**re: Geotechnical Design Summary Details**  
**Proposed Residential Development – Copperwood Estates – Block 73**  
**11 Spoor Street – Ottawa, Ontario**  
**to: Claridge Homes – Victoria St. Pierre – [victoria.stpierre@claridgehomes.com](mailto:victoria.stpierre@claridgehomes.com)**  
**date: July 24, 2026**  
**file: PG4258-MEMO.33**

Further to your request and authorization, Paterson Group (Paterson) prepared the current memorandum to provide a grading plan review for the proposed residential development. The following memorandum should be read in conjunction with Paterson Report PG4258-3 Revision 1 dated July 24, 2026.

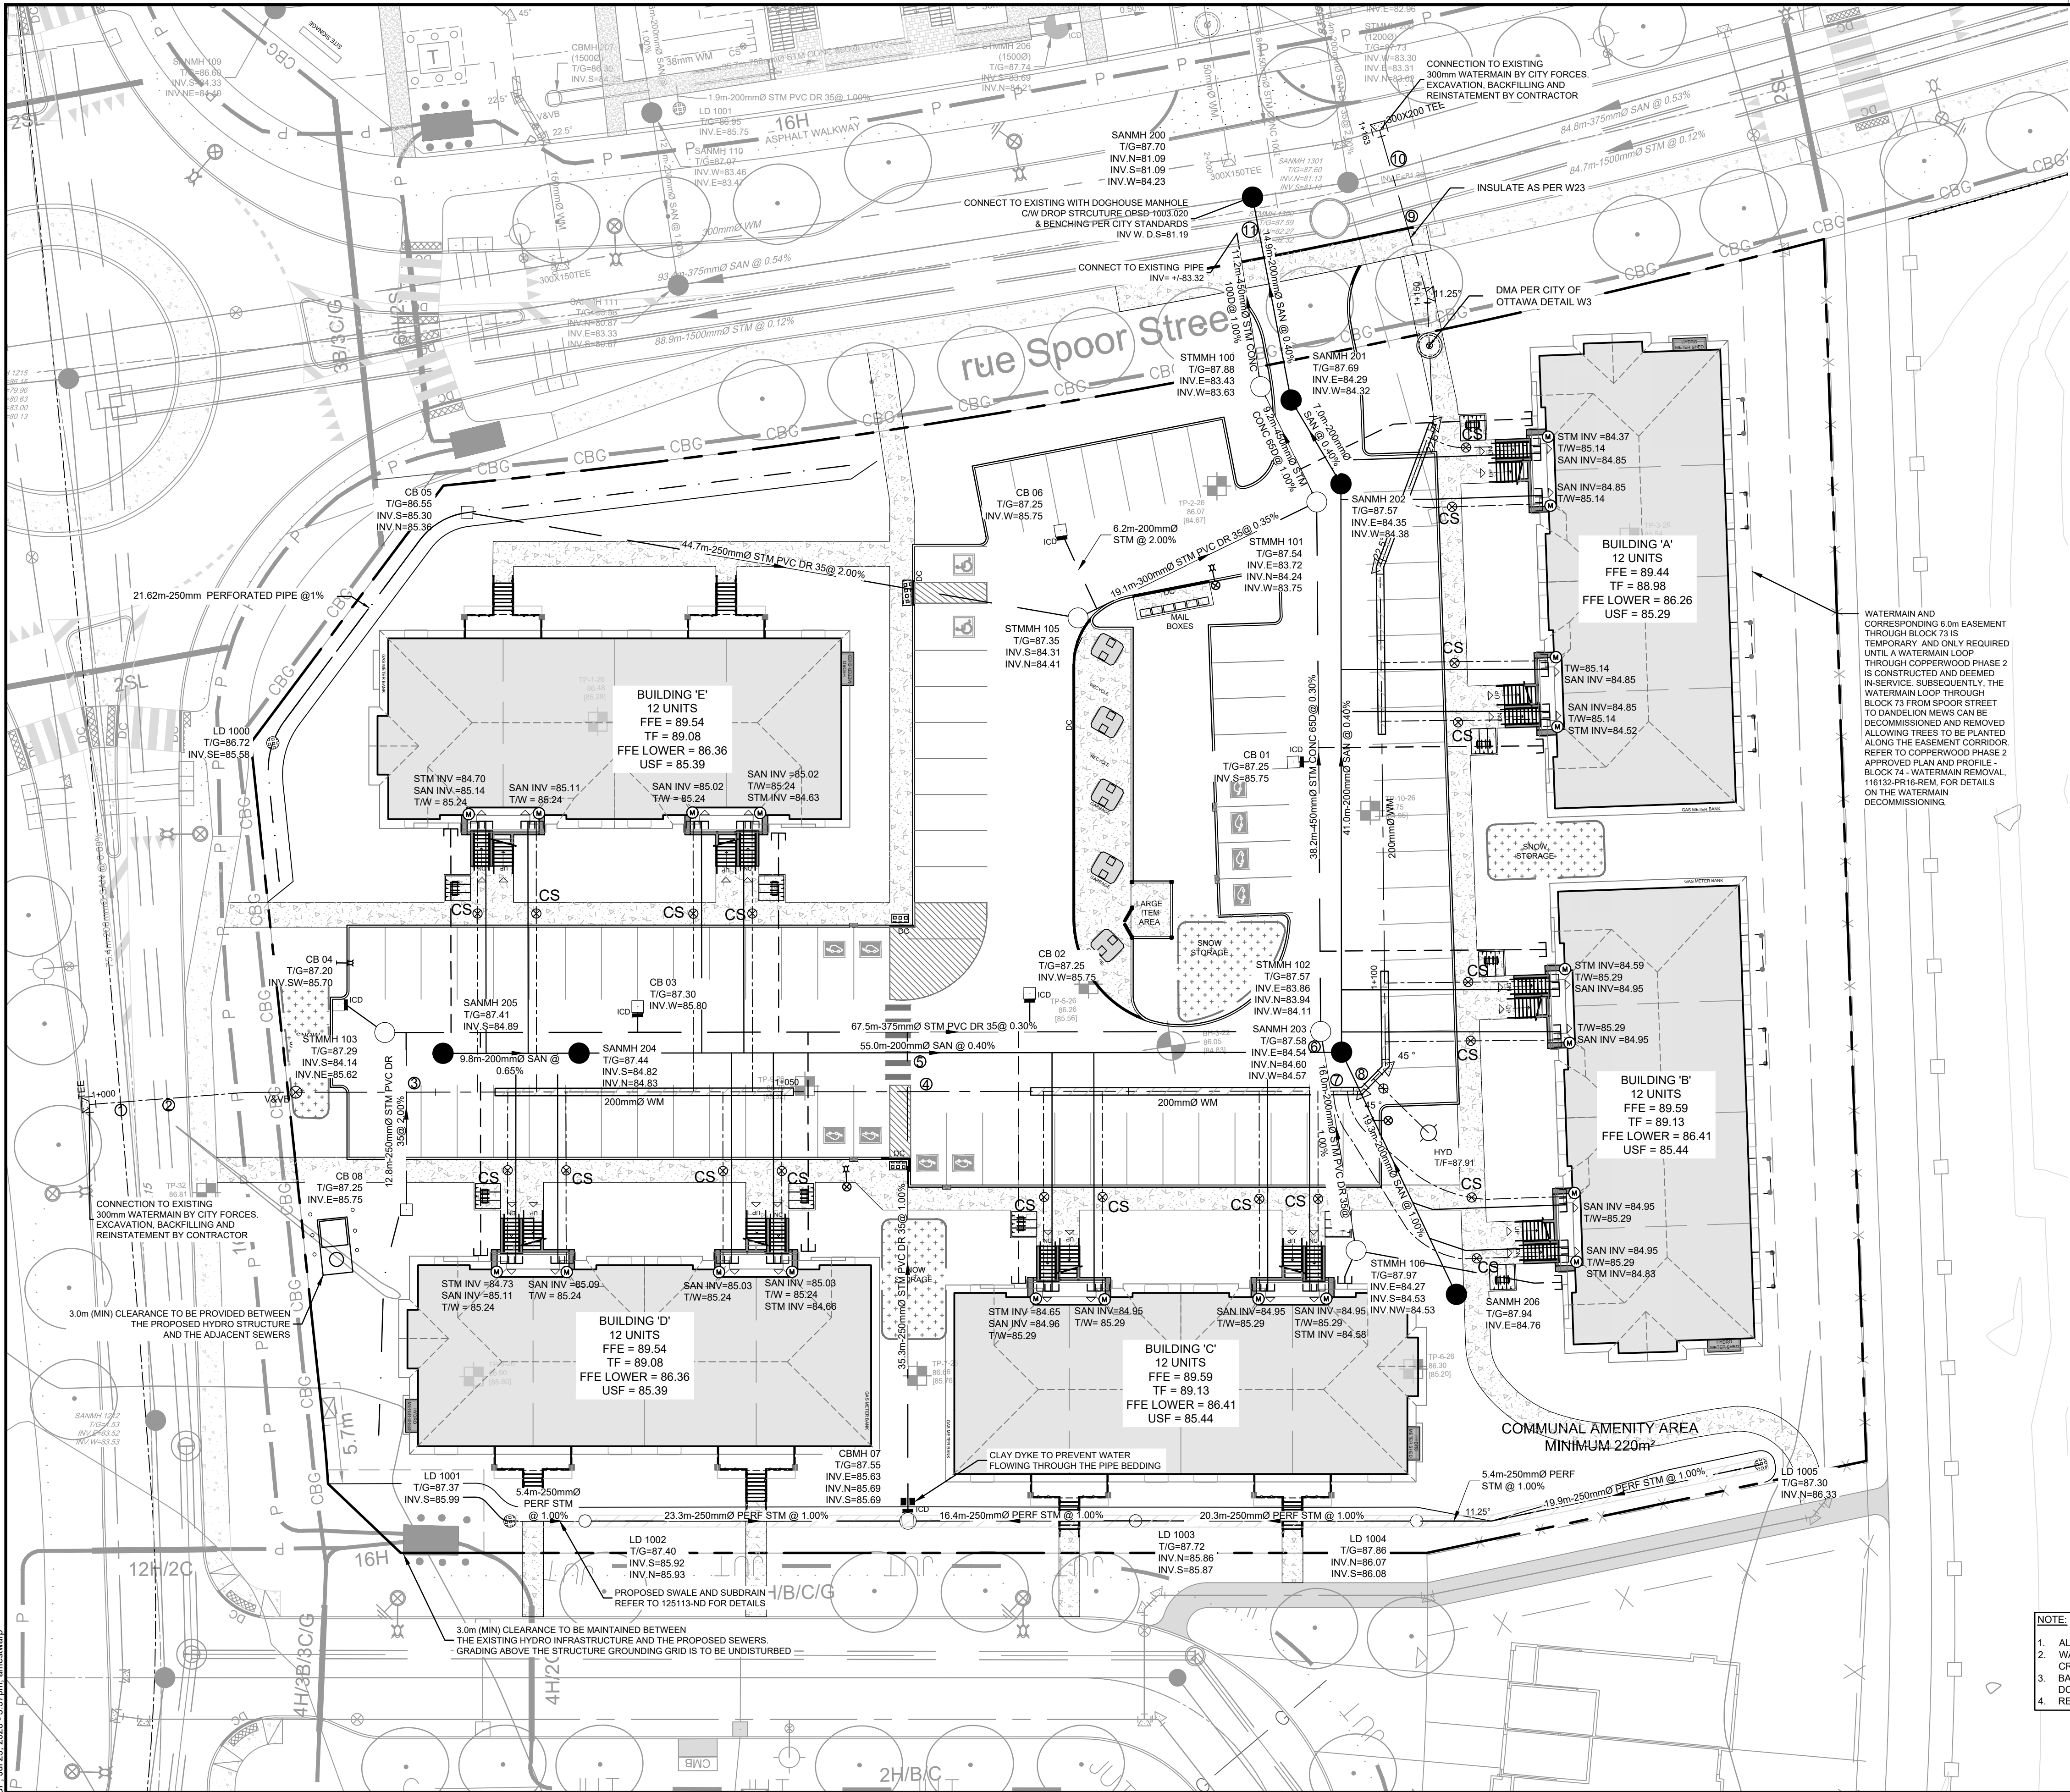
Based on the above-noted site servicing plan, the site servicing layout does not impede the lateral support zones of any adjacent buildings/structures and is acceptable from a geotechnical perspective.

The service connections to the proposed buildings are lower than the underside of footing (USF) elevation.

If the service connections will be installed prior to building construction, reinstatement of the bearing medium below the footings and within the lateral support zones will be required. To achieve this, it is recommended that the excavations are backfilled within either 15 MPa 28-day strength concrete, or OPSS Granular B Type II placed in maximum 300 mm thick loose lifts and compacted to a minimum of 98% of the material's standard Proctor maximum dry density (SPMDD).

If the footings will be placed prior to service connection installation, it is recommended that the USF is lowered to an elevation below the service connection elevation via concrete trench using 15 MPa 28-day strength concrete and the service connections should be sleeved through the footings/foundation walls. The lowered USFs should extend a minimum of 2.4 m laterally from the exterior edge of all service pipe connections.

Based on the above-noted site servicing plan, adequate soil cover for frost protection is provided to all services.

PROJECT No.	125113
REV	REV #2
DRAWING No.	125113-GR

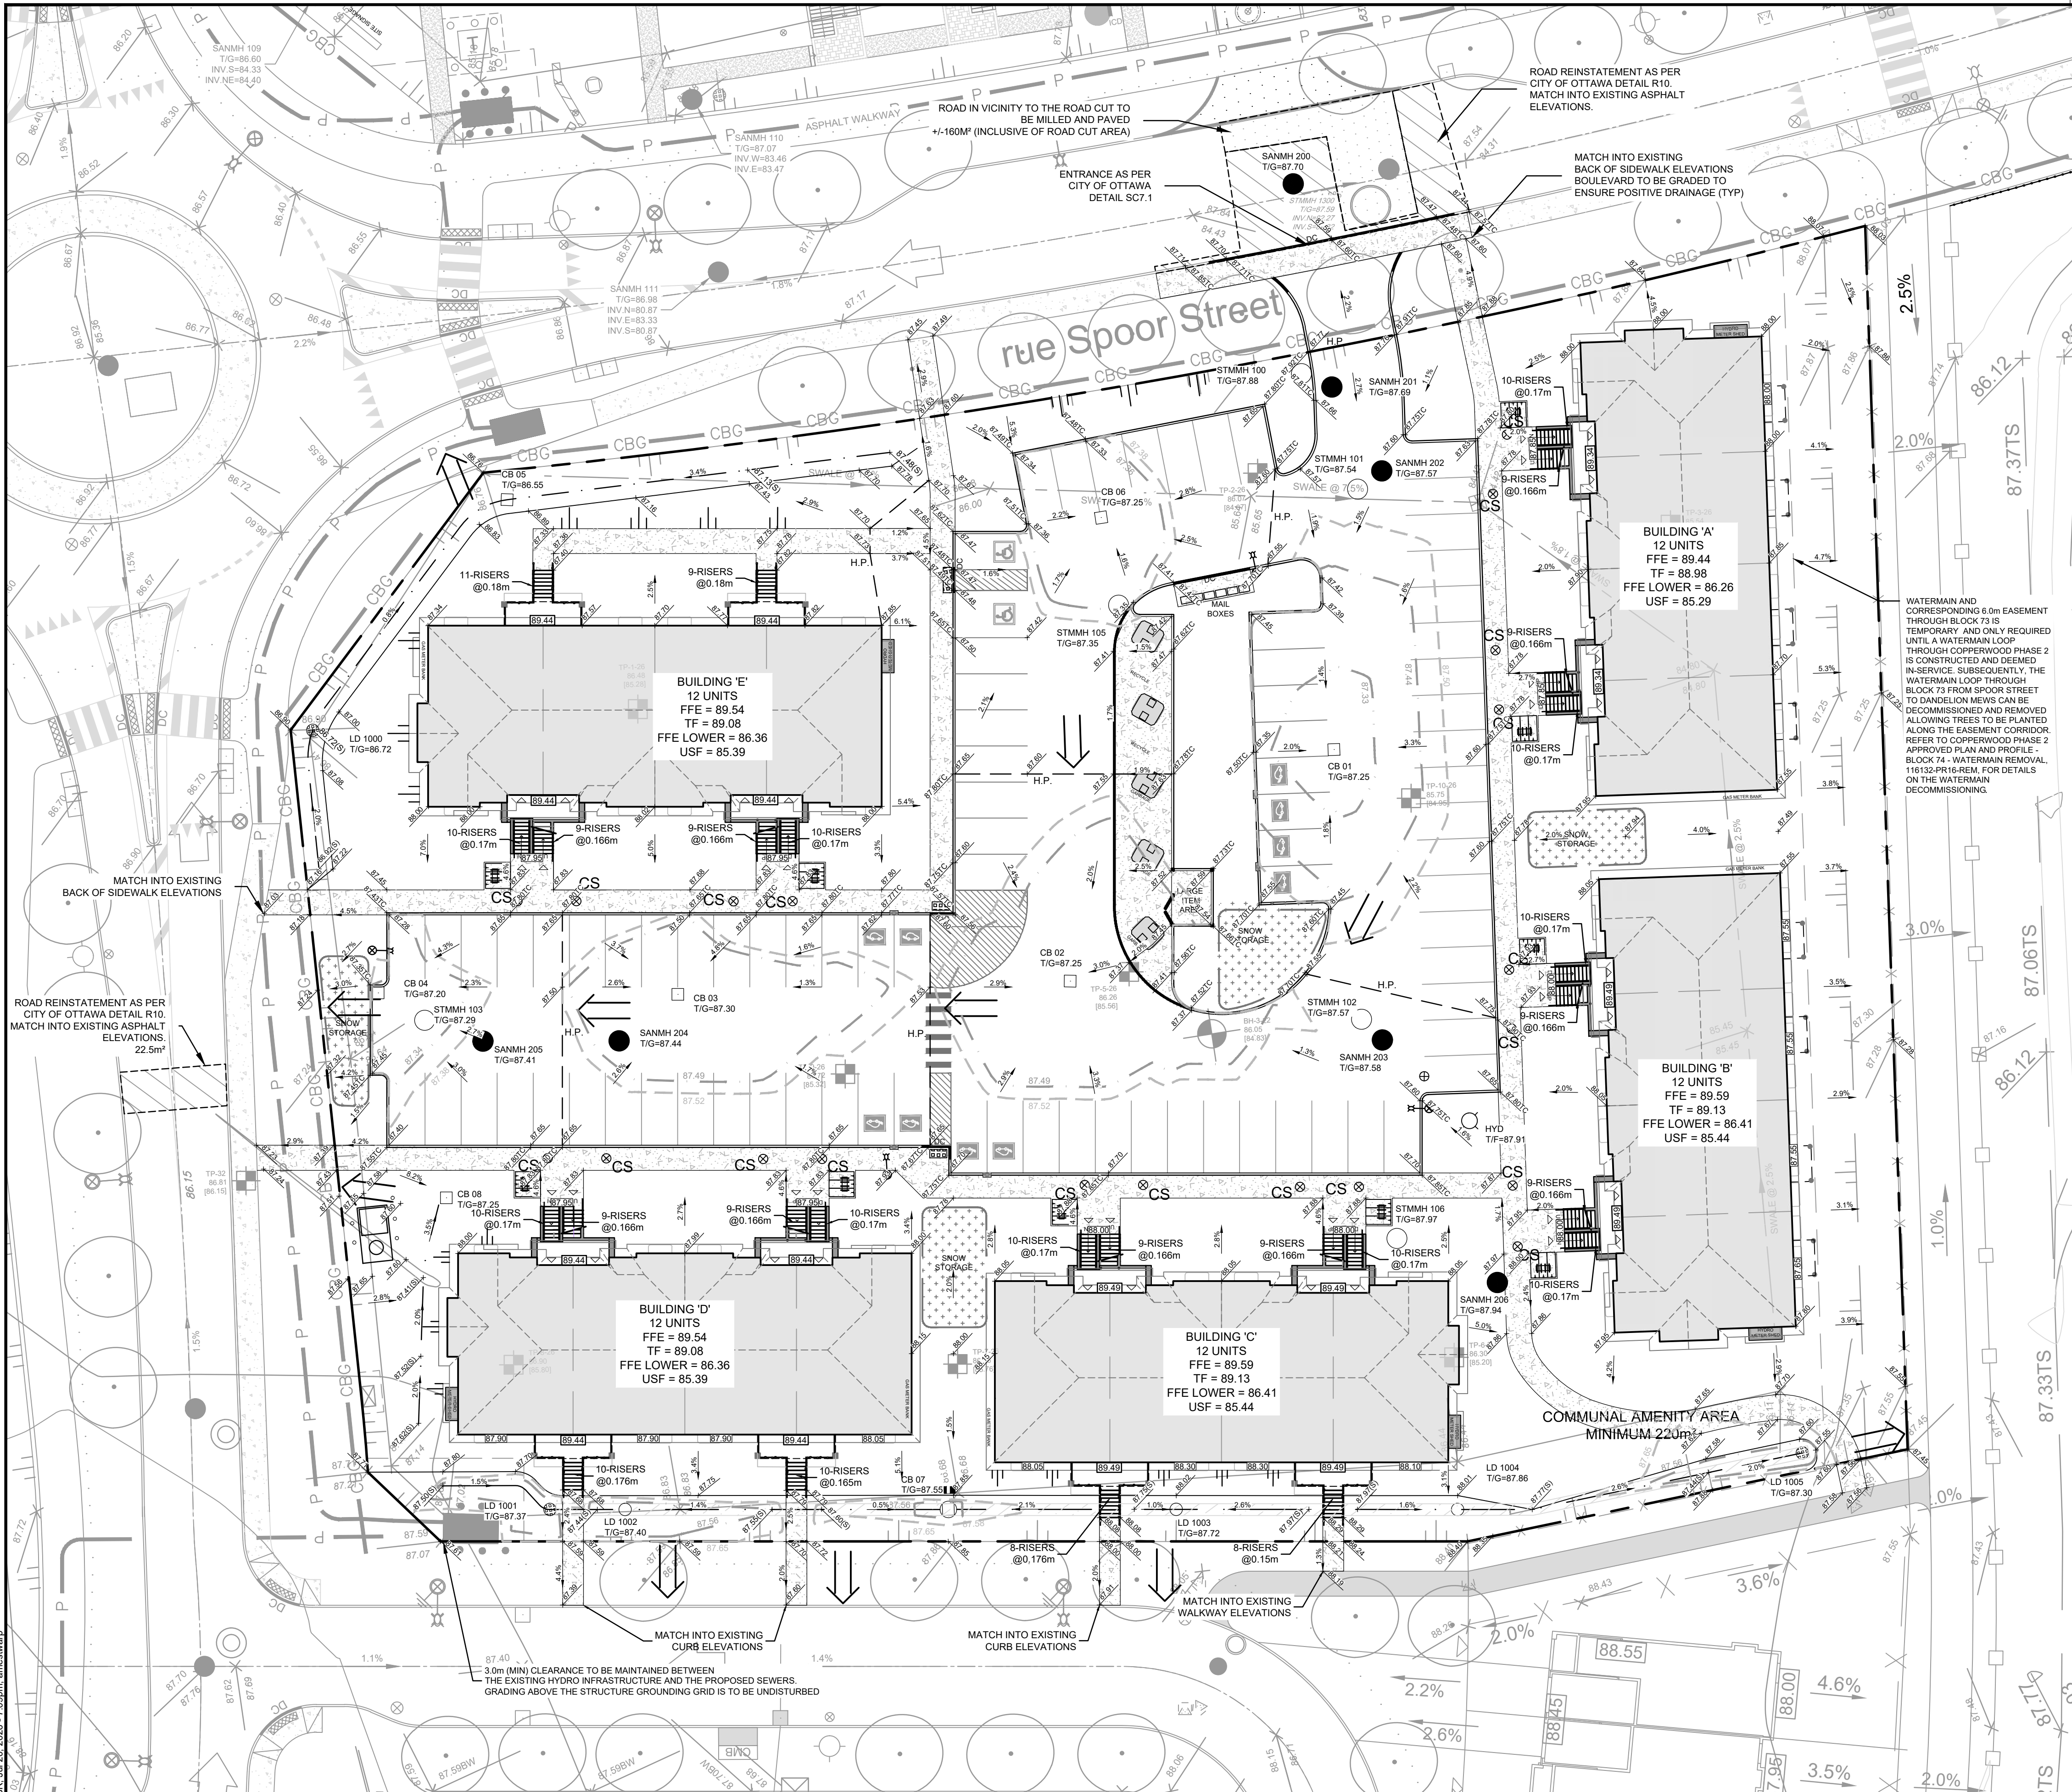
Based on review of the above-noted grading plan, the proposed residential and right-of-way grading for the subject site are considered acceptable from a geotechnical perspective and in conformance with our recommendations. Due to the lack of silty clay within the subject site, a permissible grade raise restriction is not applicable. As such, lighttight fill is not required and standard construction practices are acceptable.

Furthermore, adequate soil cover (1.5 m or greater) for frost protection is provided for all buildings within the proposed development. Therefore, additional measures for frost protection (such as rigid insulation) are not required.
